MEMORANDUM

TO: Jean Fraser, Planner
FROM: David Senus, P.E.
DATE: May 13, 2015
RE: 1342 Congress Street Neighborhood Center, Preliminary Level III Site Plan Application

Woodard & Curran has reviewed the Preliminary Level III Site Plan Application response to comments submittal for the for the proposed Neighborhood Center at 1342 Congress Street. The project involves the construction of a 19,300 SF building with associated site improvements that include a surface parking lot, stormwater management system, utilities, site lighting, and landscaping. The project will disturb approximately 85,000 SF and result in 12,500 SF of additional impervious area.

SC-310 CHAMBER SYSTEM CROSS-SECTION
NOT TO SCALE

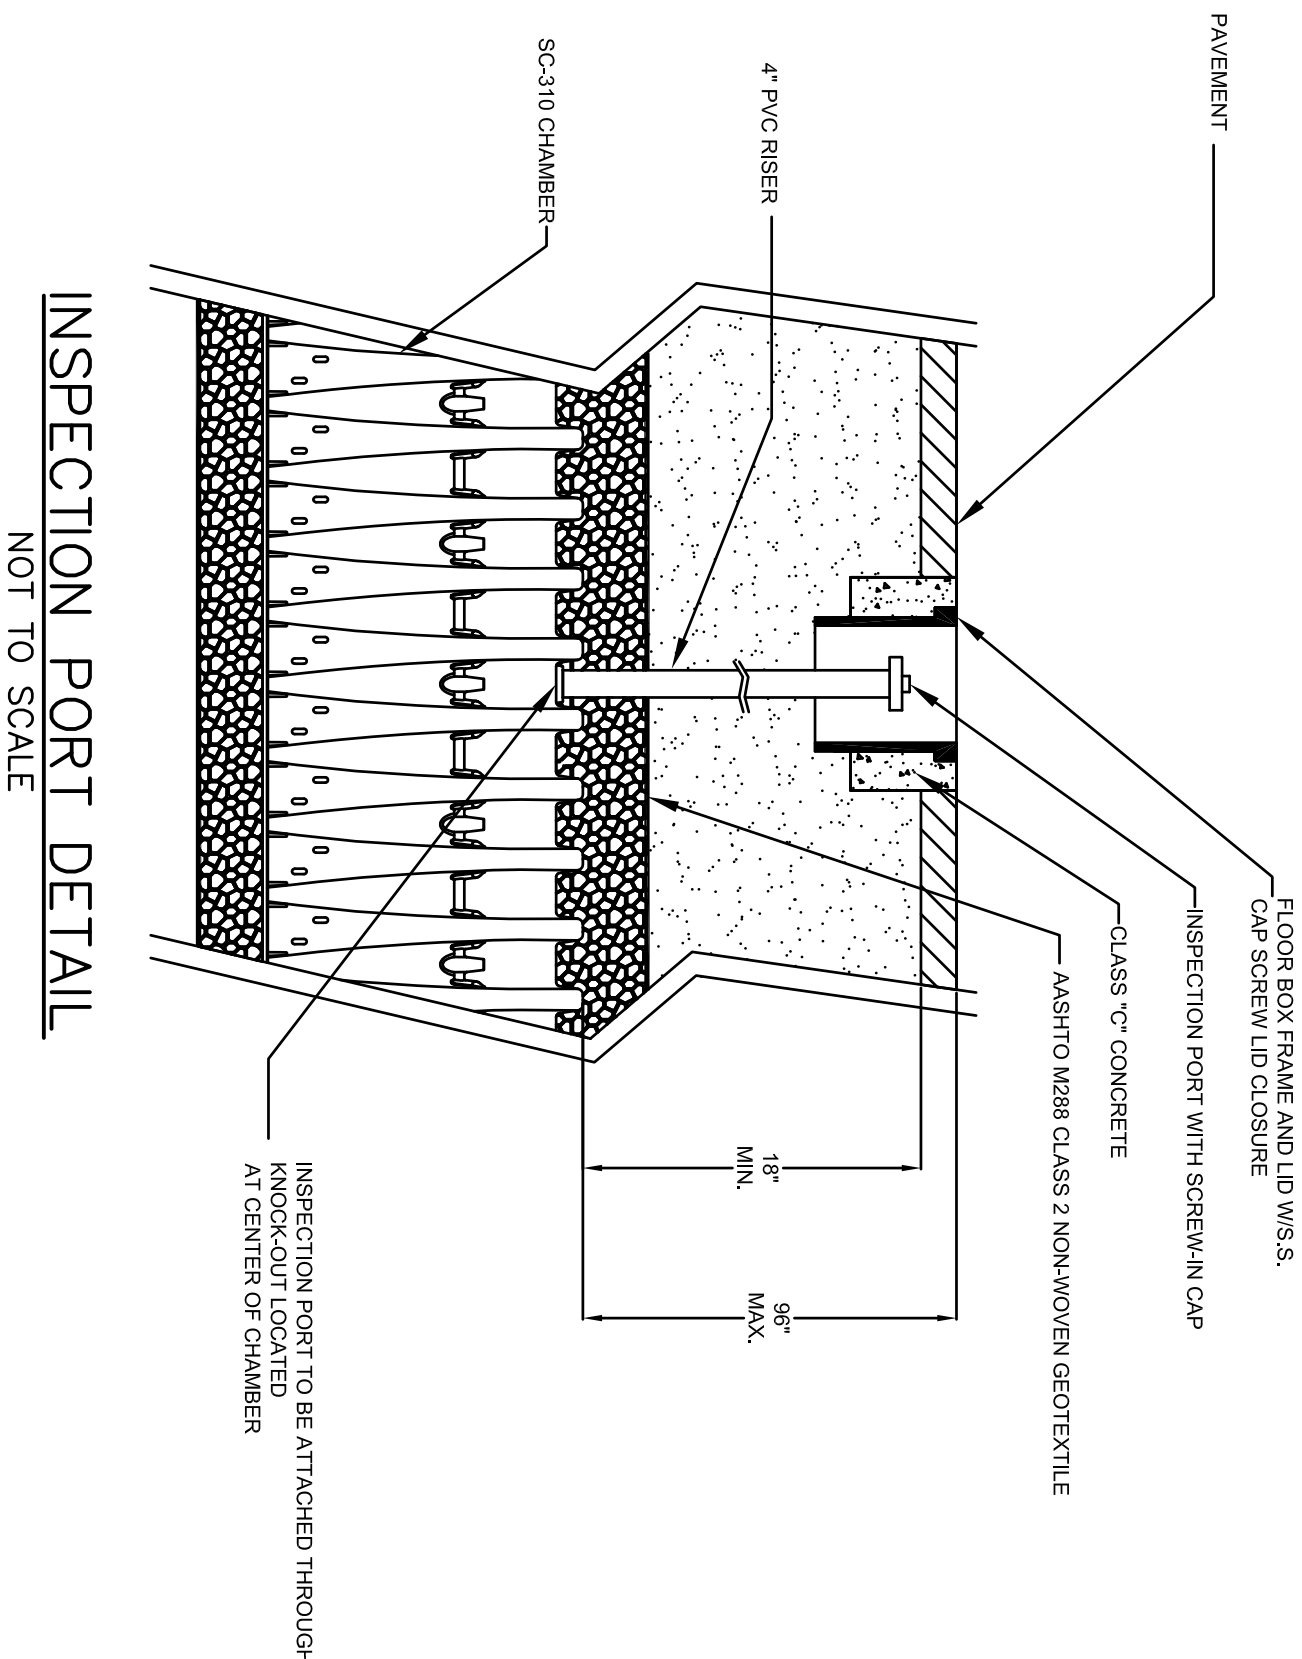
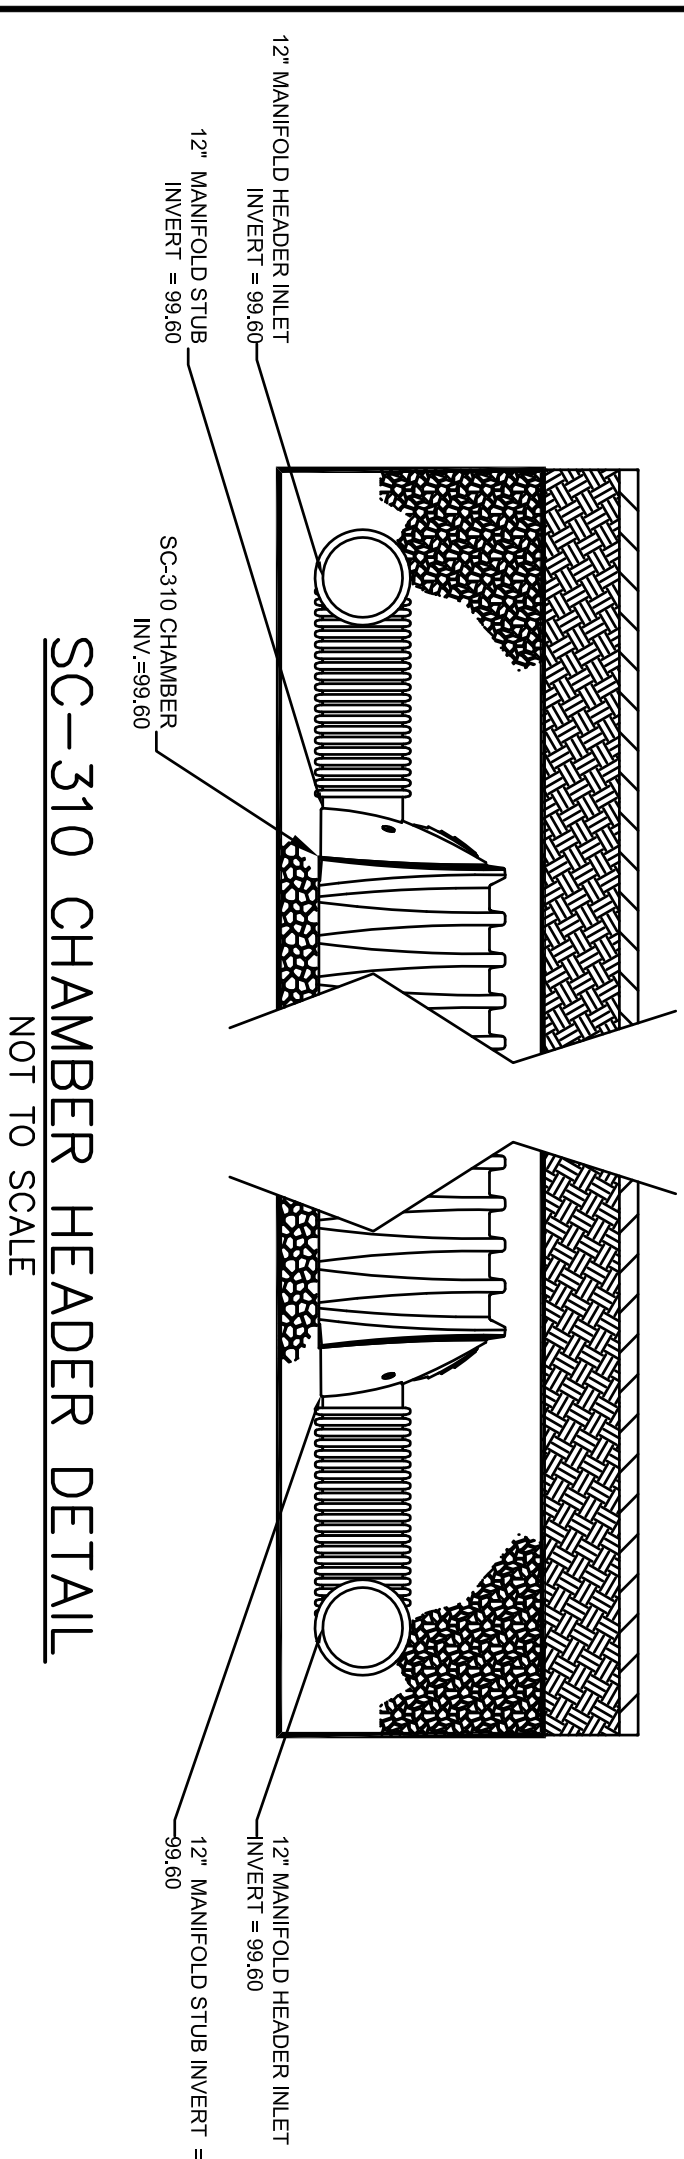
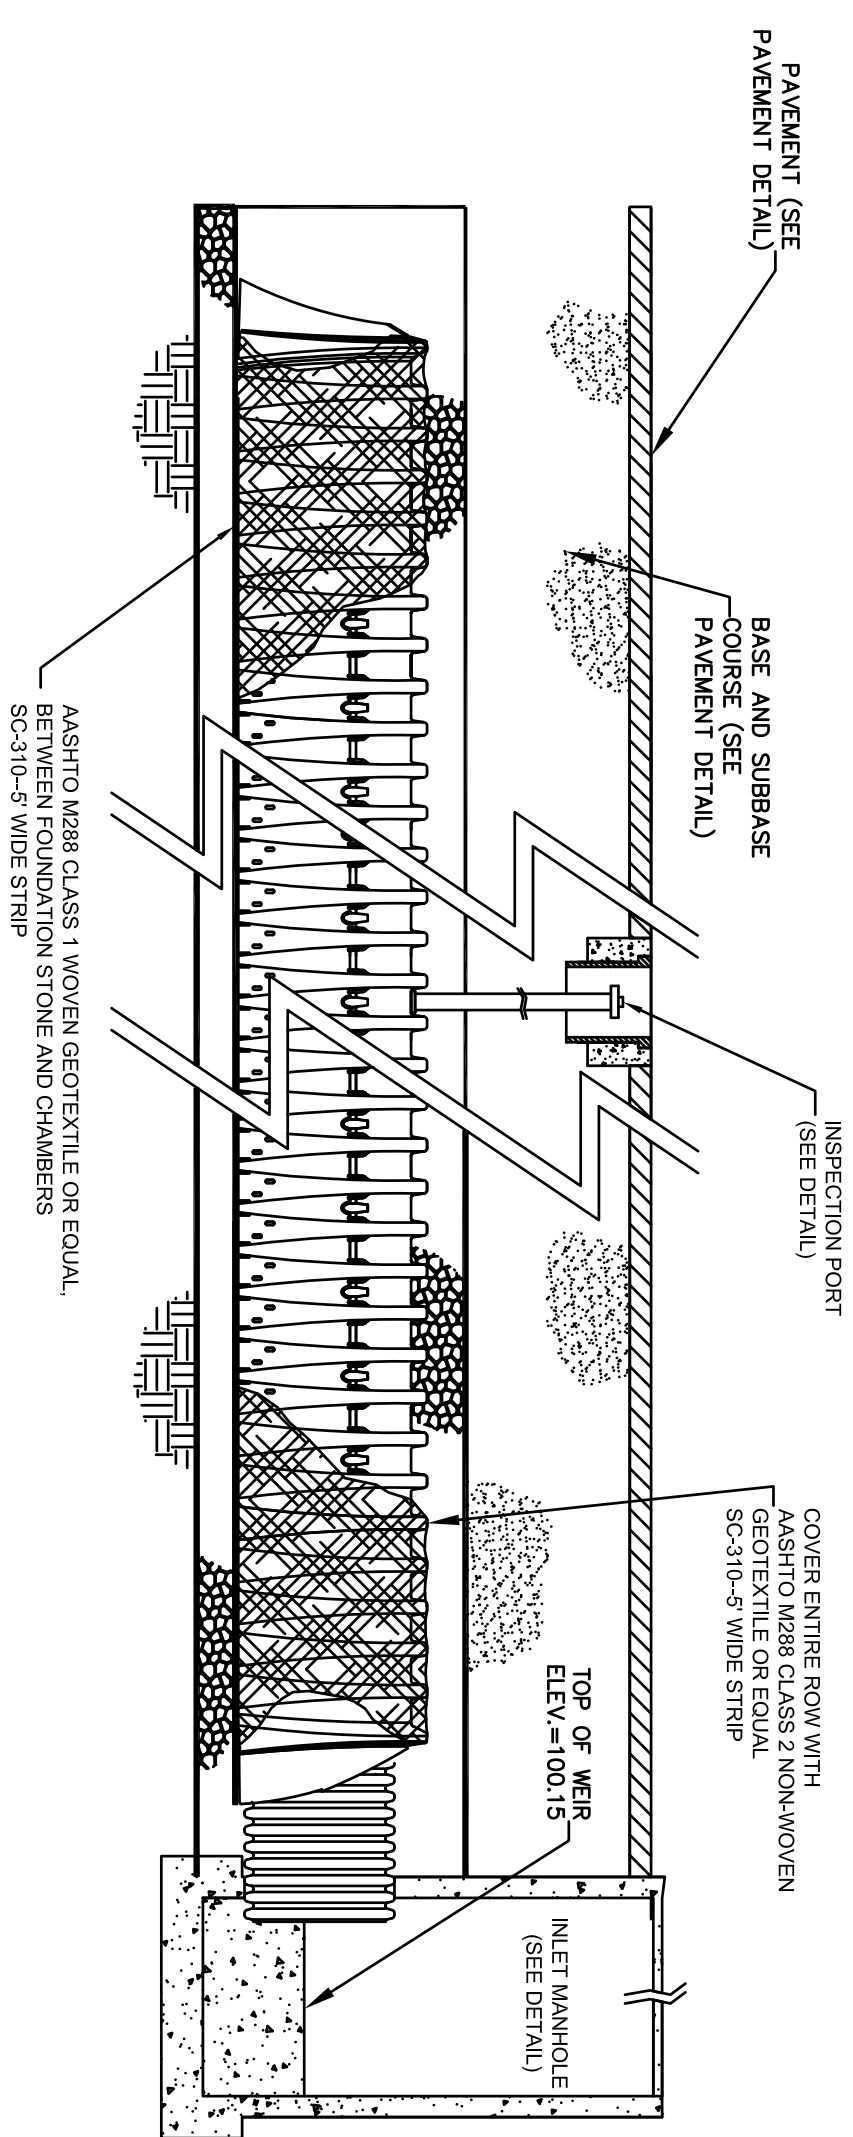
Comment adequately addressed – Details provided.
 - iii) Future submittals should identify key elevations for the StormTech Chamber detail matching to the elevations utilized in the HydroCAD model.

Comment adequately addressed – Details provided.
 - iv) The Pre-Development Watershed Plan (WS-1) indicates that runoff from the existing building roof is part of catchments WS-1 and WS-2; however, runoff from some of these roof areas is collected in downspouts that enter into the ground and which do not appear to flow to PA-1 and PA-2. The Applicant should determine the discharge location for the building's roof downspouts and re-evaluate the catchment areas and stormwater model based on their findings.
The Applicant's engineer has stated that they are actively working with the Owner to determine the outlet locations of the roof drains. As part of the future, final submittal, the Applicant will revise the Pre- Development Watershed Plan (WS-1) and drainage design (if needed) to account for updated roof drainage information.

VERTICAL GRANITE CURB
NOT TO SCALE

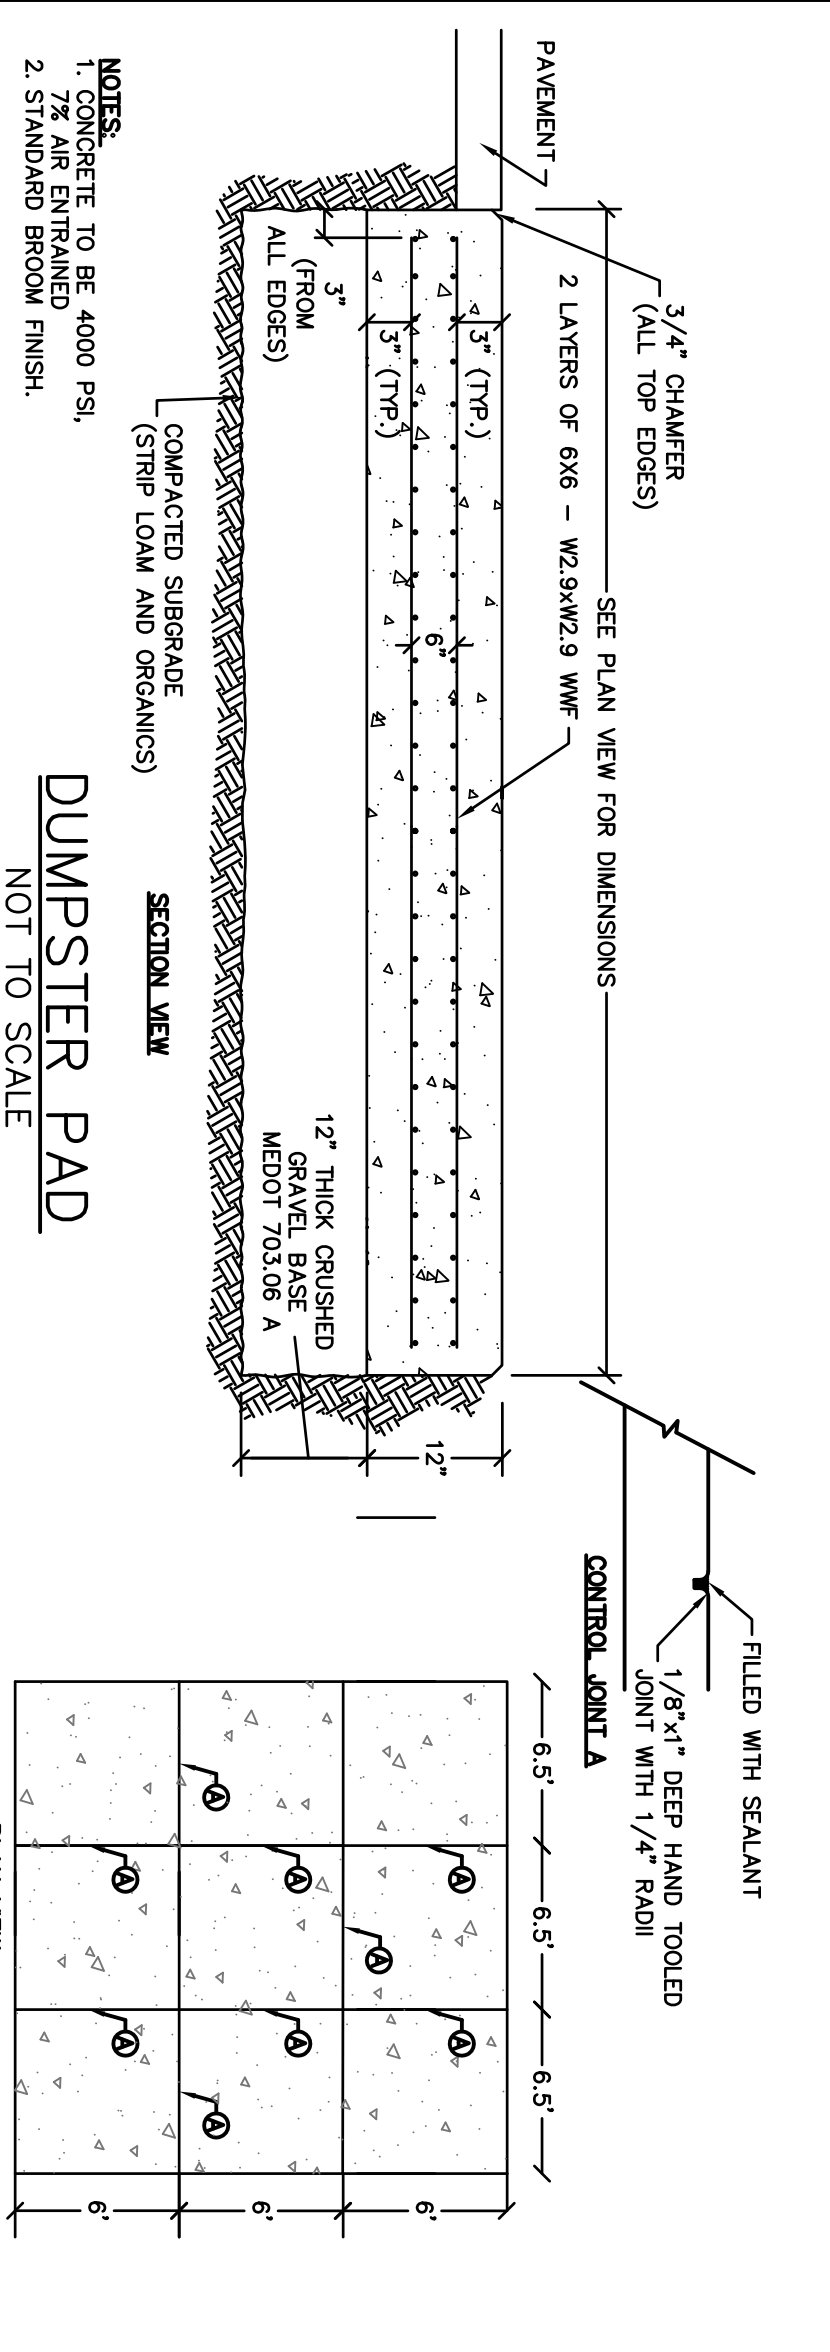
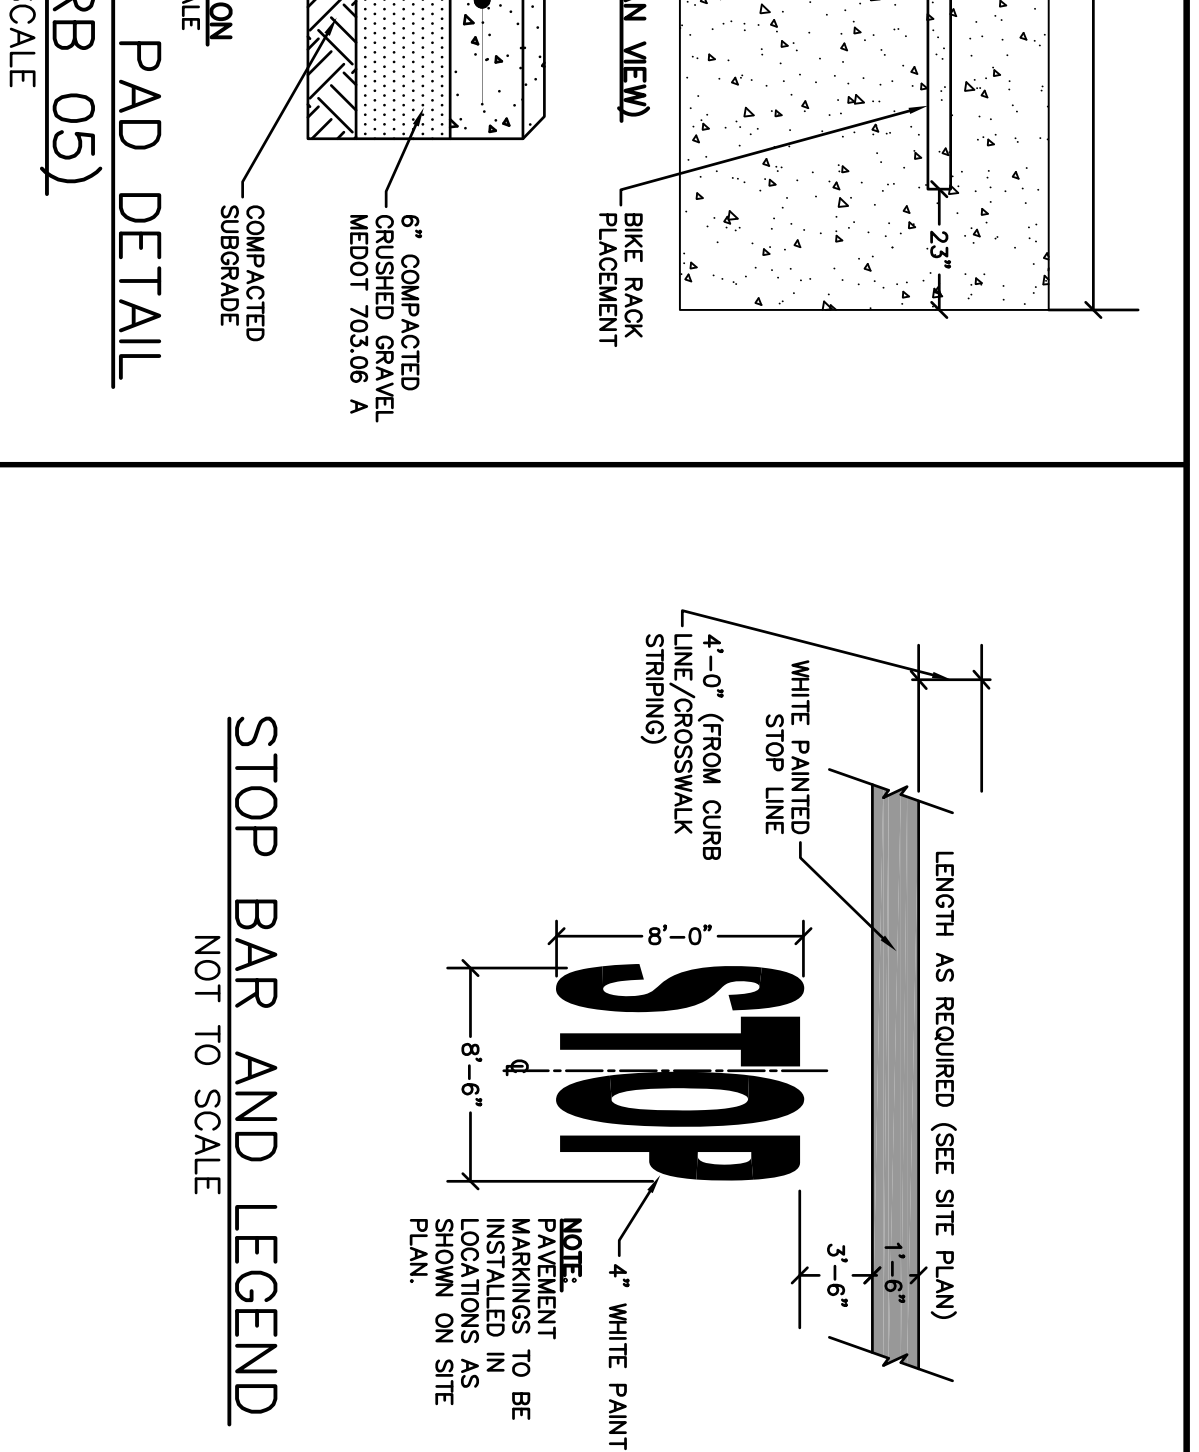
- 7) The proposed Vertical Granite Curb, Concrete Sidewalk, and Utility Trench details should be revised to comply with the City of Portland Technical Manual for work within the City Right-of-Way.

Comment adequately addressed – Details provided.
